CUMNOR PARISH COUNCIL

BOTLEY WEST SOLAR FARM (BWSF) REF: EN010147

In response to your 11th June 2026 invitation to respond to submissions made to your 28th April 2026 Request For Information, Cumnor Parish Council (CPC) as an Interested Party (IP) is today submitting two documents to you by email:

Photovoltaic Development Partners GmbH
Kurfürstendamm 52
10707 Berlin, Germany

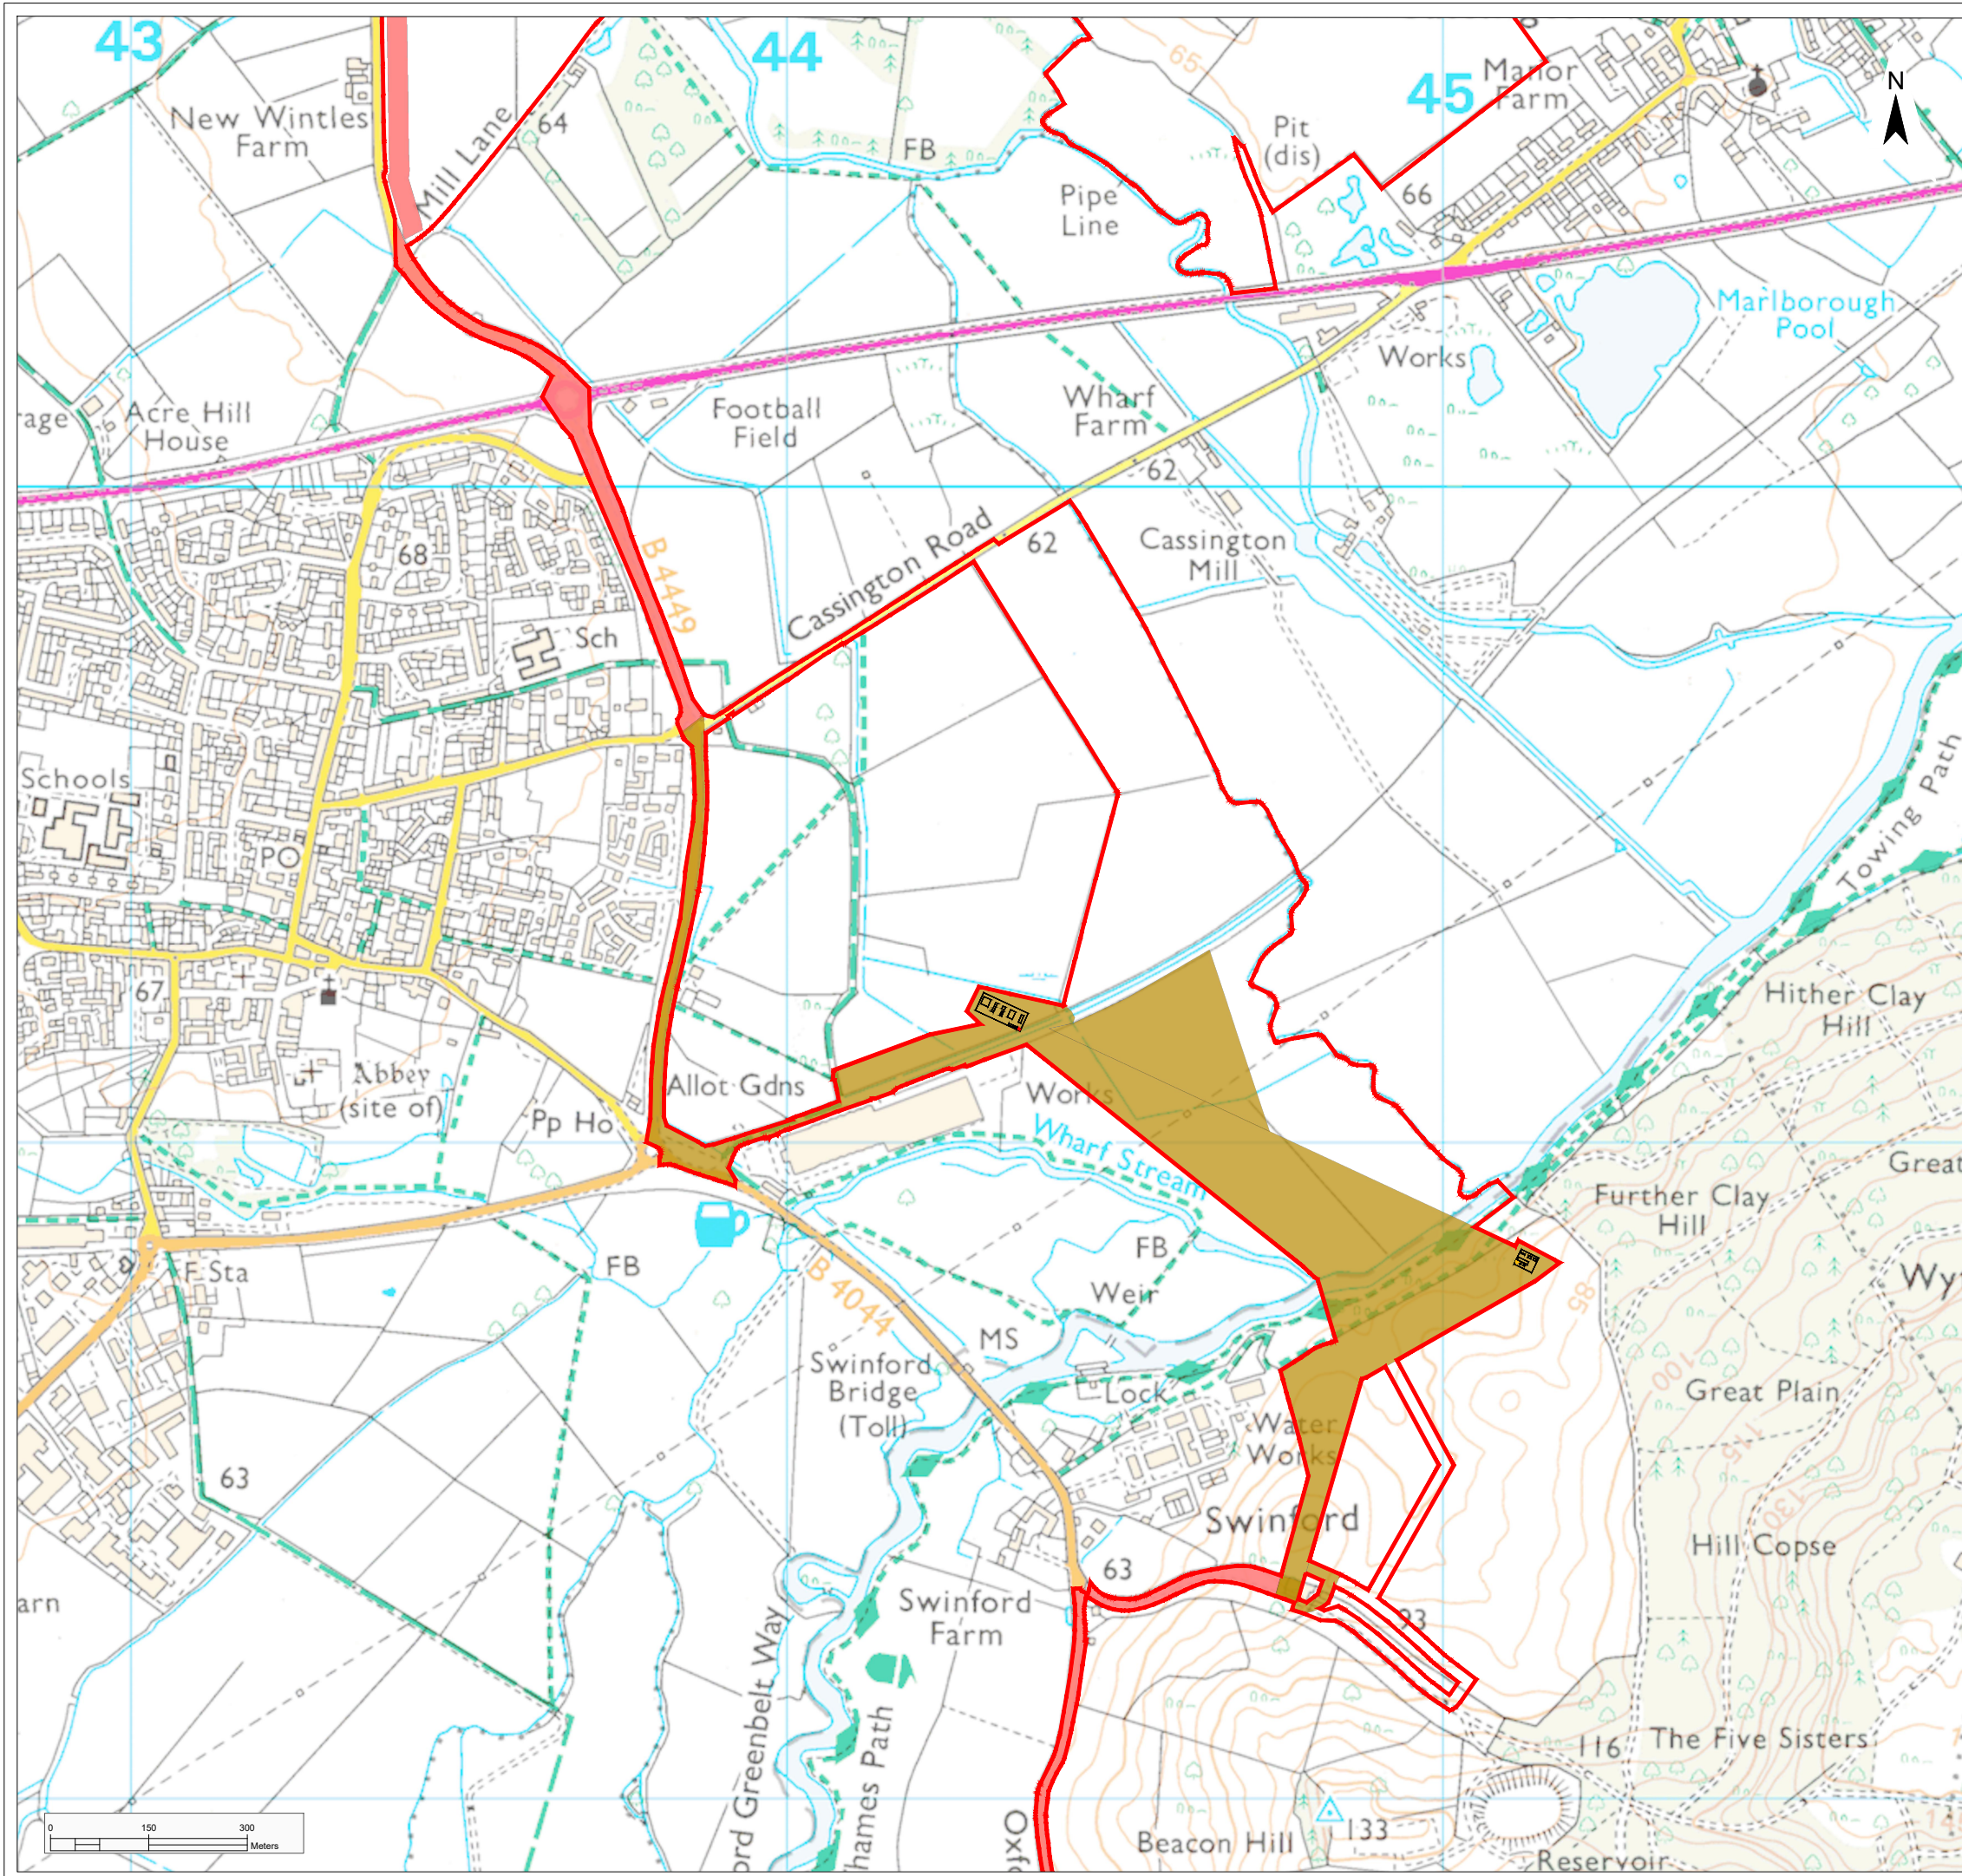
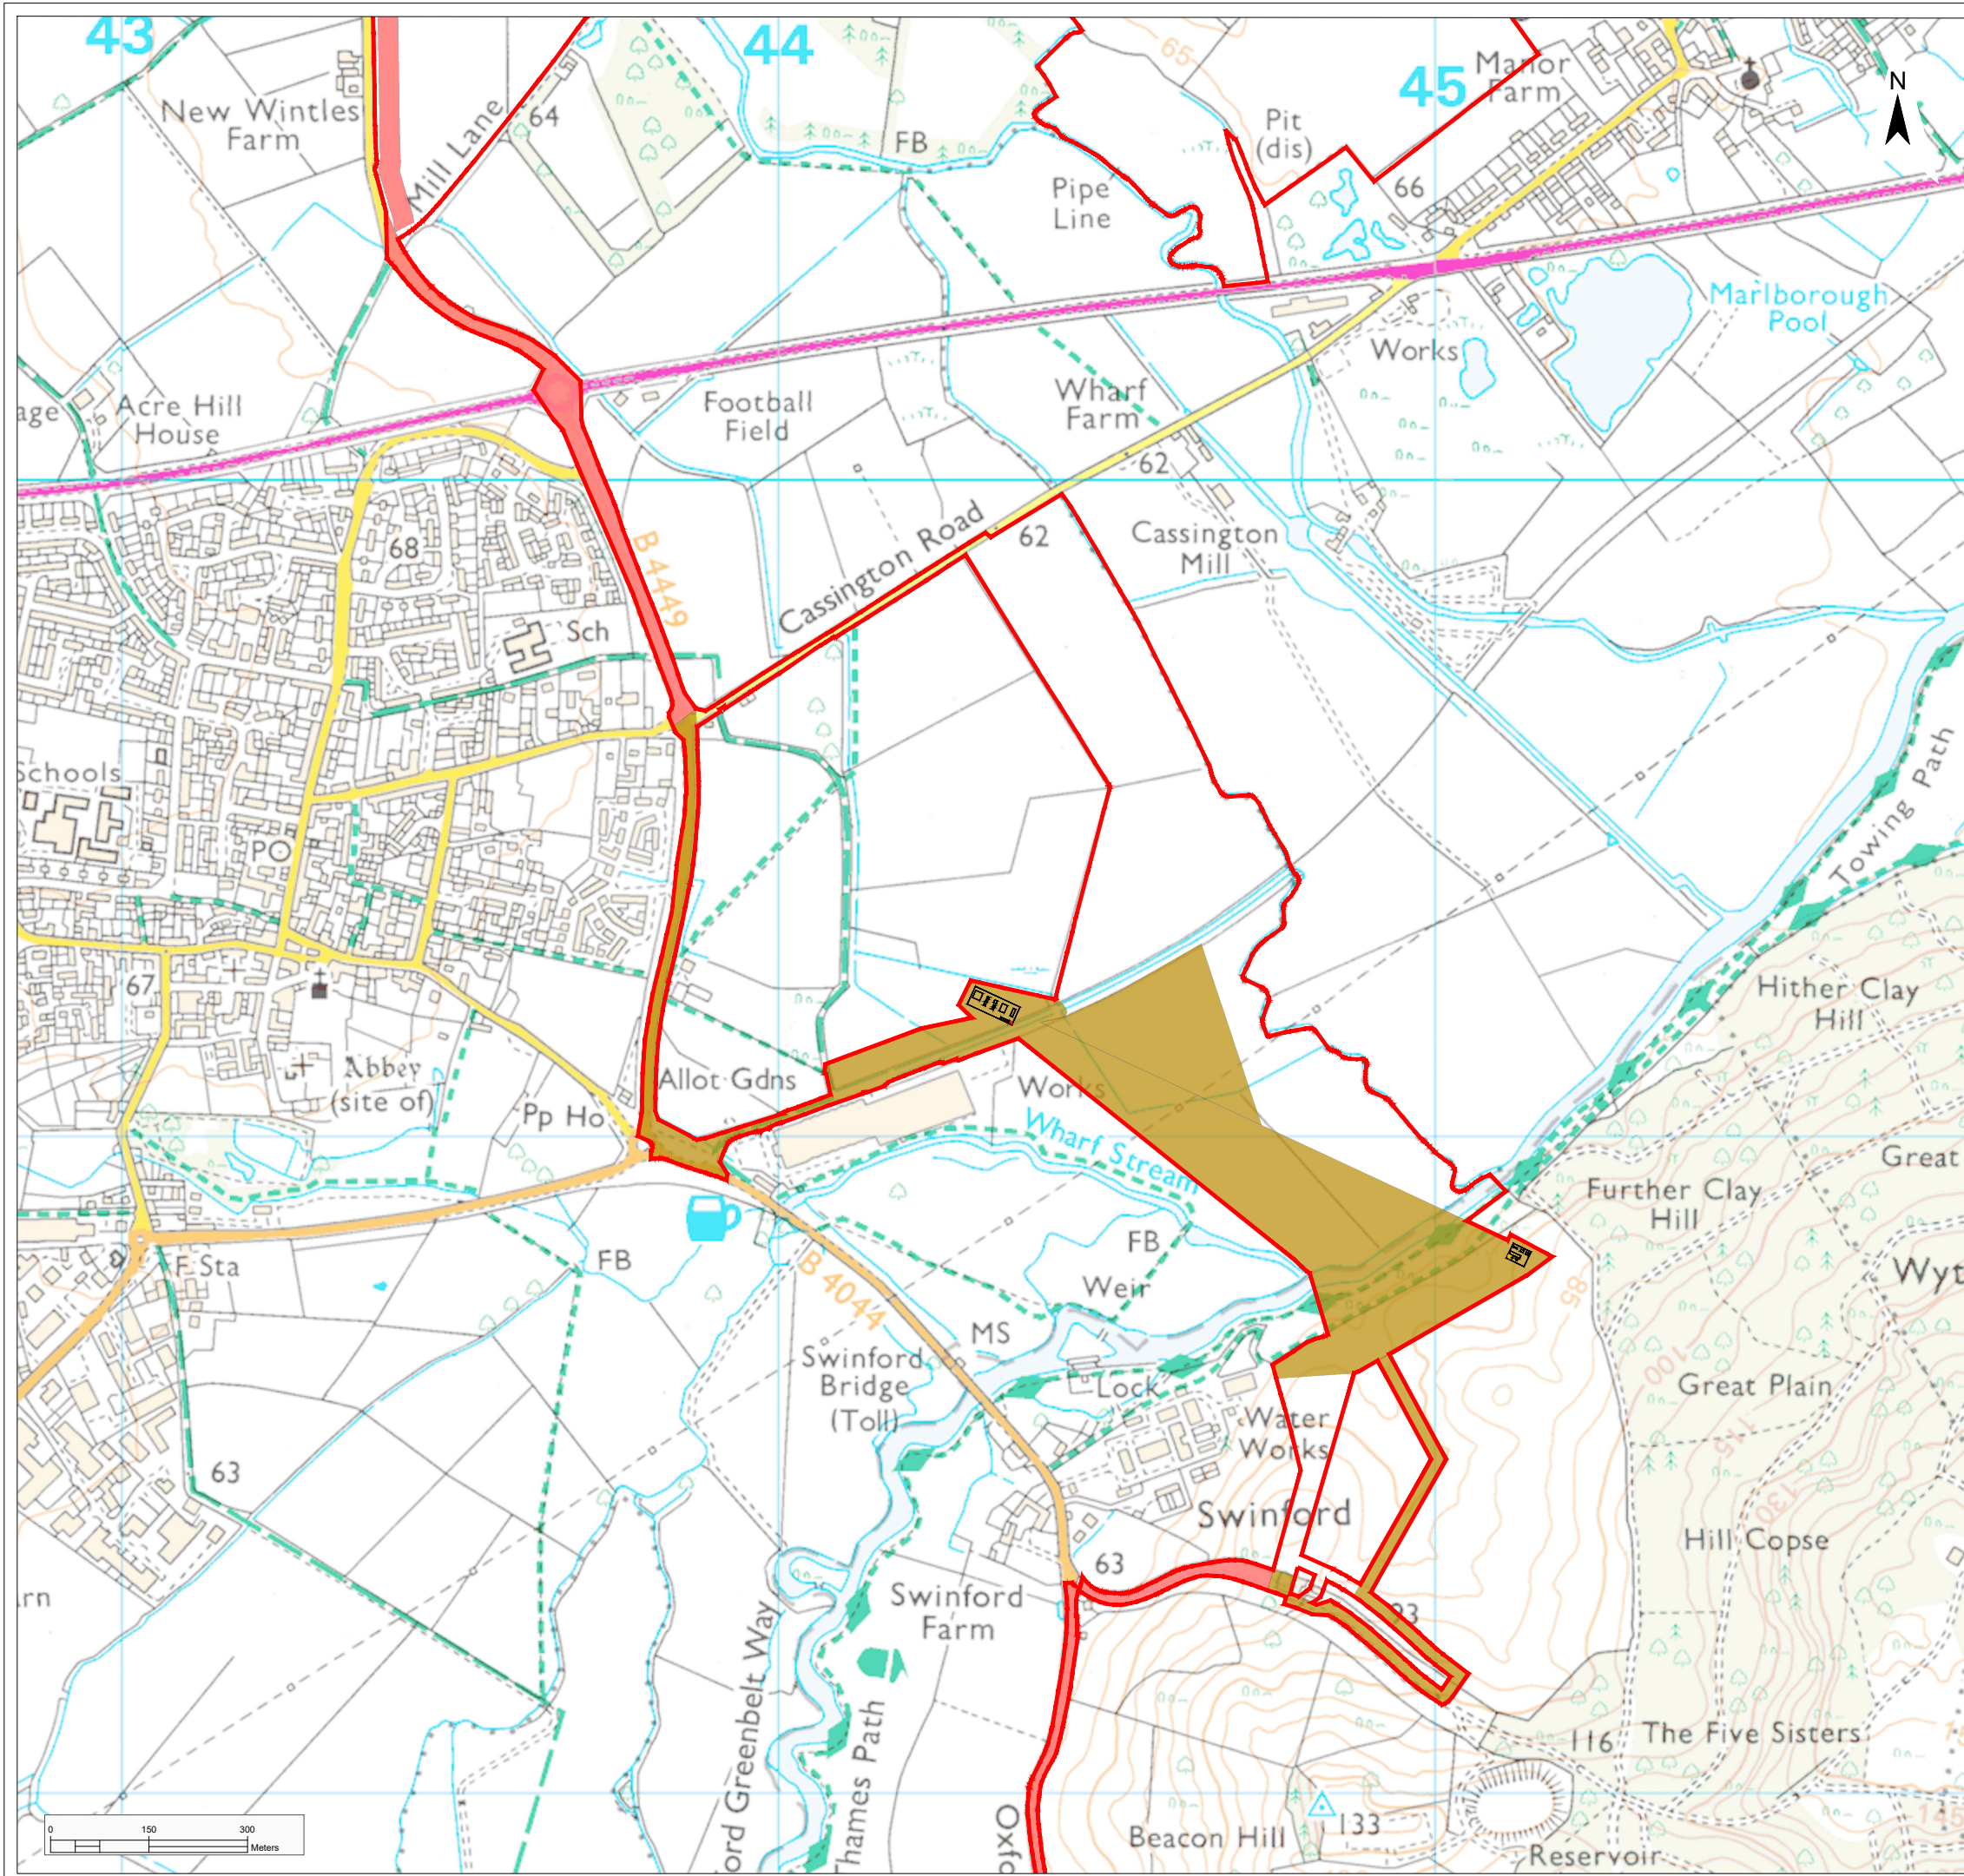
Unfortunately for the Applicant all these impediments are apparently surmountable for their proposed cable connection between the central and southern sites where there are:

- Local Nature Reserves present along the route corridor.
- Ancient woodland blocks (including Wytham woods SSSI)
- River Thames crossing at Swinford: Flood Risk Zones 2 and 3 are present at this crossing - Environment Agency consent required.
- Additional Flood Zone 2 / 3 sections present including the B4044 SW of Swinford (see Map 2 - EA flood risk map - below)

Surprisingly given the Applicant's stated unwillingness to address these impediments for a contrived cable route to Cowley, it is apparently content to cope with them for its central site to southern site cable route.

Except of course it hasn't addressed them in this case either, the prime example being the absence of a '*detailed flood risk assessment*' that satisfies this Interested Party or the OHA for the southern site and the central to southern site cable routing.

Also unexplained is why, if the Applicant is unwilling to bear a cost of c. £10m/km for cabling to Cowley (the Applicant quotes a cost of £150m for 15km to Cowley from the southern site **C1-087 pages 9 and 10**), it is willing to bear that same £10m/km cost, with a total of at least £70m for the c. 7km cable route between the central and southern sites traversing the River Thames near to Swinford Toll bridge in a EA Flood Zone 3 area?
